Report to Wollstonecraft Precinct

Crow's Nest Over Station Development (SSD-9579)

Photomontage of proposed envelope

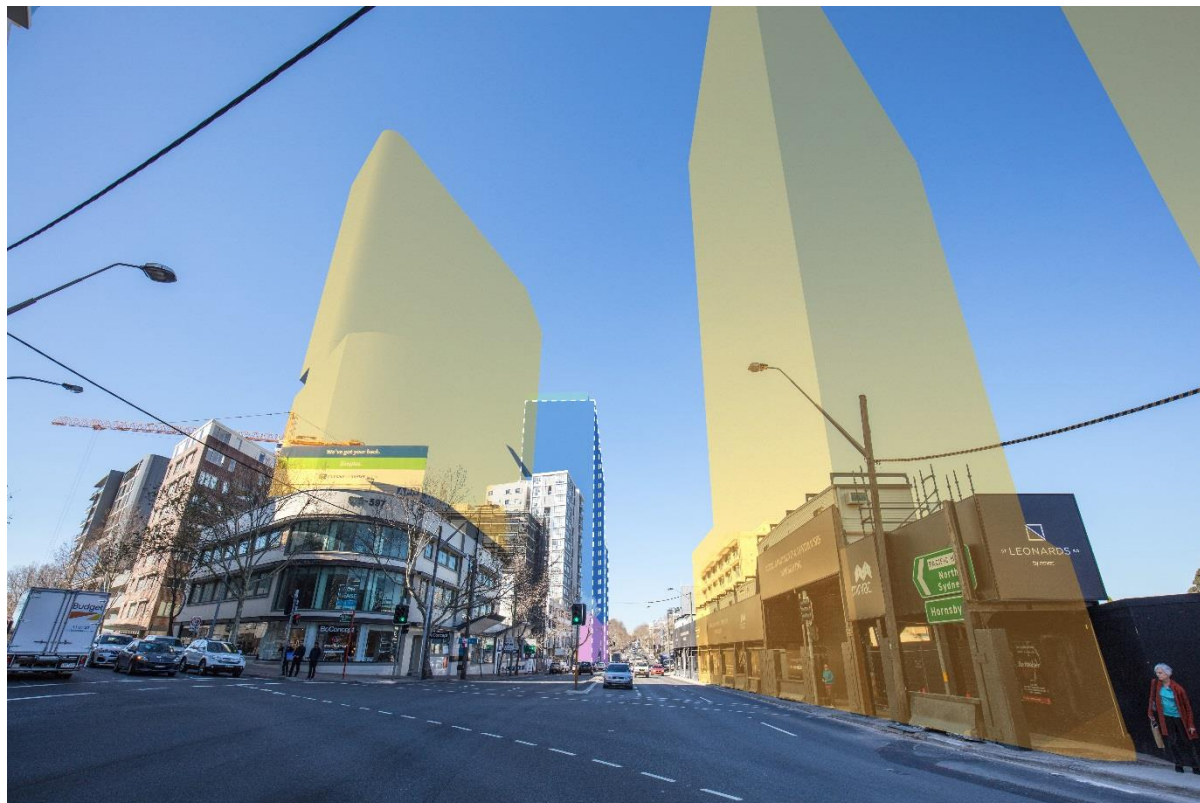
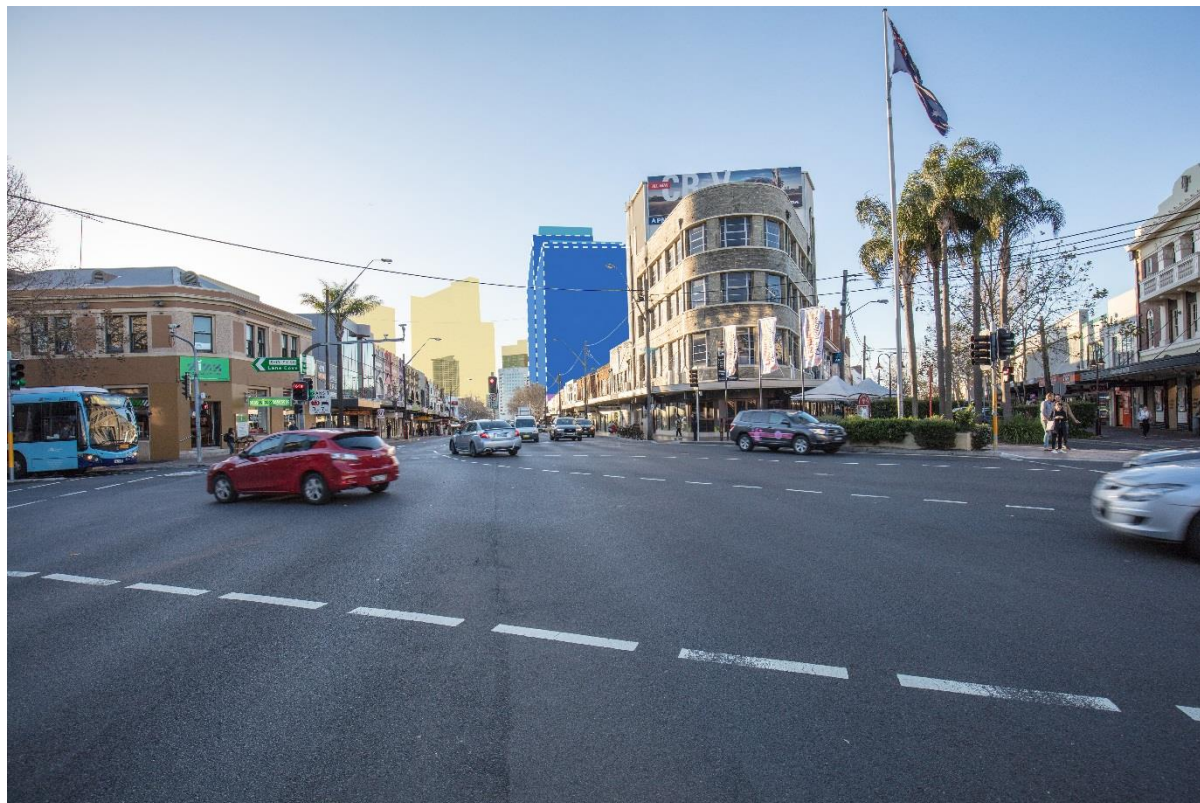
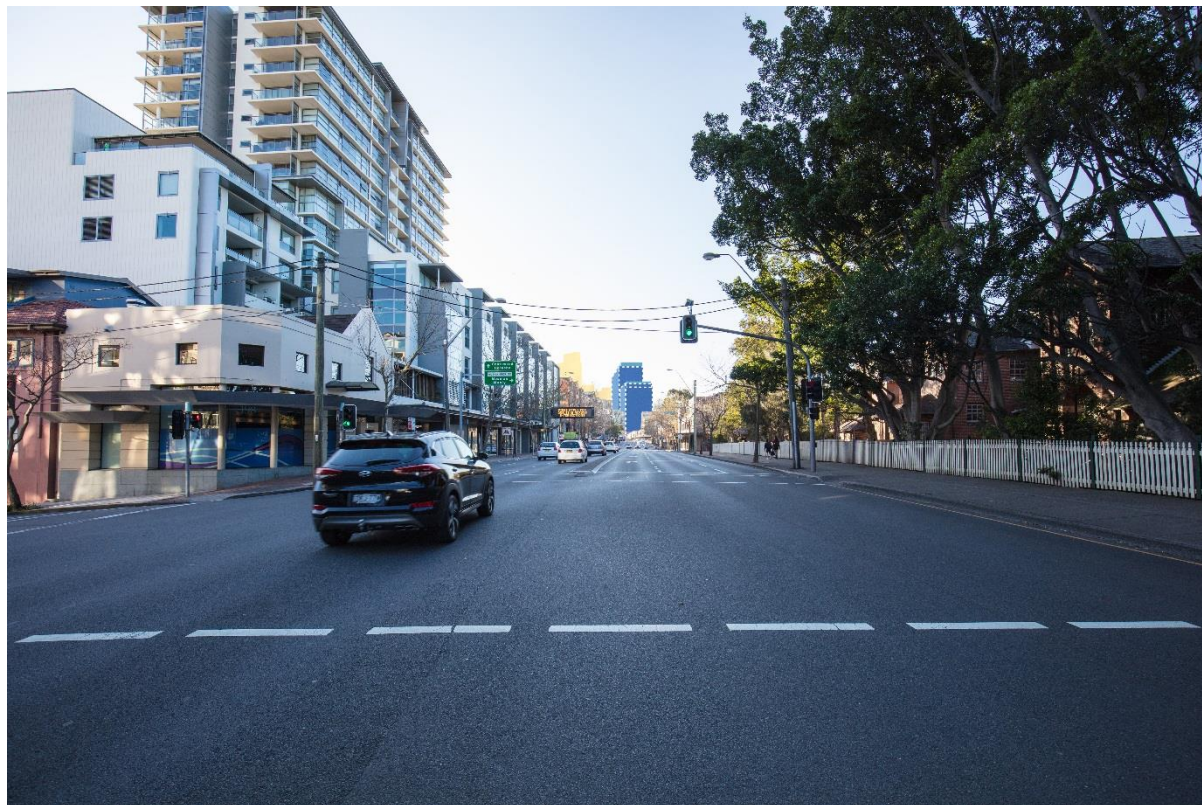
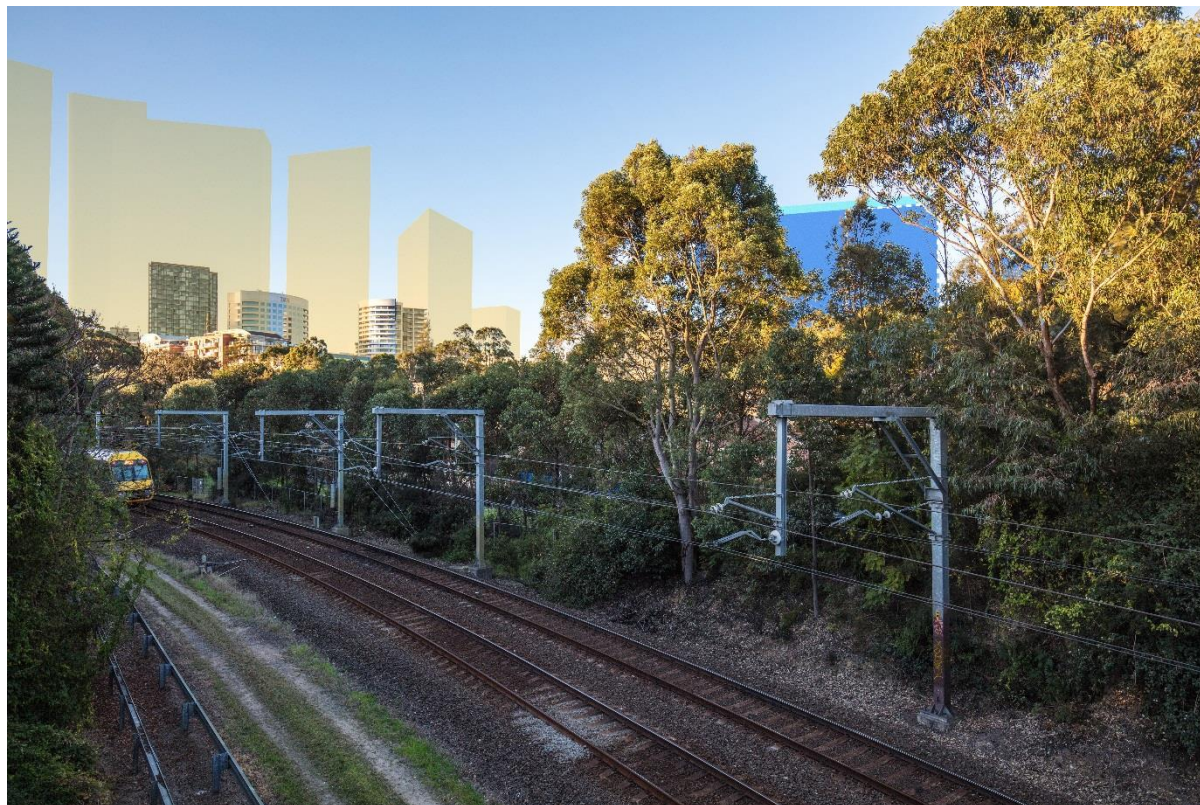
By any analysis the visual impact remains significant. Site A in particular occupying the whole block will be dominant with only partial relief due to the sloping south face. The two photomontages supplied in the RtS showing the original exhibited proposal and the amended proposal are at different scales and give a false impression that the amended proposal is much smaller in overall impact than the original. In fact, this impression is misleading. However, it can be readily seen that the building on Site A is much larger (occupying a full block) than the lower of the two Mirvac towers at St Leonards Square, a development that has demonstrably very high adverse visual impact from all angles and distance.

3 WEST ELEVATION - PACIFIC HIGHWAY 1:1500

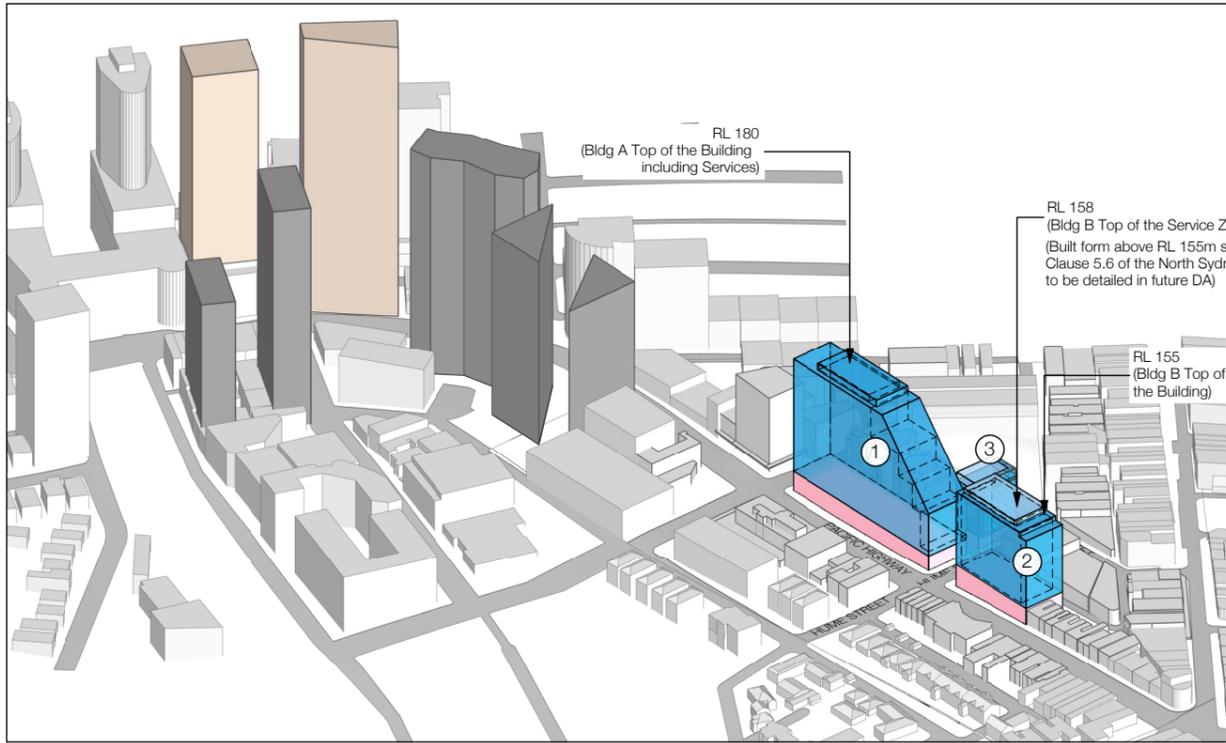
It is acknowledged that the new commercial office building on Site 'A' has a changed envelope, but the 20% reduction is misleading. The envelope ignores the fact there were originally two towers proposed on this block with a large gap between.

Taking into account the net area of the western faces, the commercial office building even with the steppes towards the south, is only 6% less than that of the twin towers. Hence its bulk and scale will be a blot on the landscape and will forever block out sky views as well as reducing solar access. It will be entirely out of context with the low rise suburb of East Wollstonecraft and the Crows Nest village.

The shadow diagrams for this building, ignore what will now be a future 24 storey mixed use/residential development on the opposite side of the highway. Shadows from that building in the afternoon will eliminate the effect of the stepped face of the OSD building A and as a result worsen the effect of shadowing to Willoughby Road.
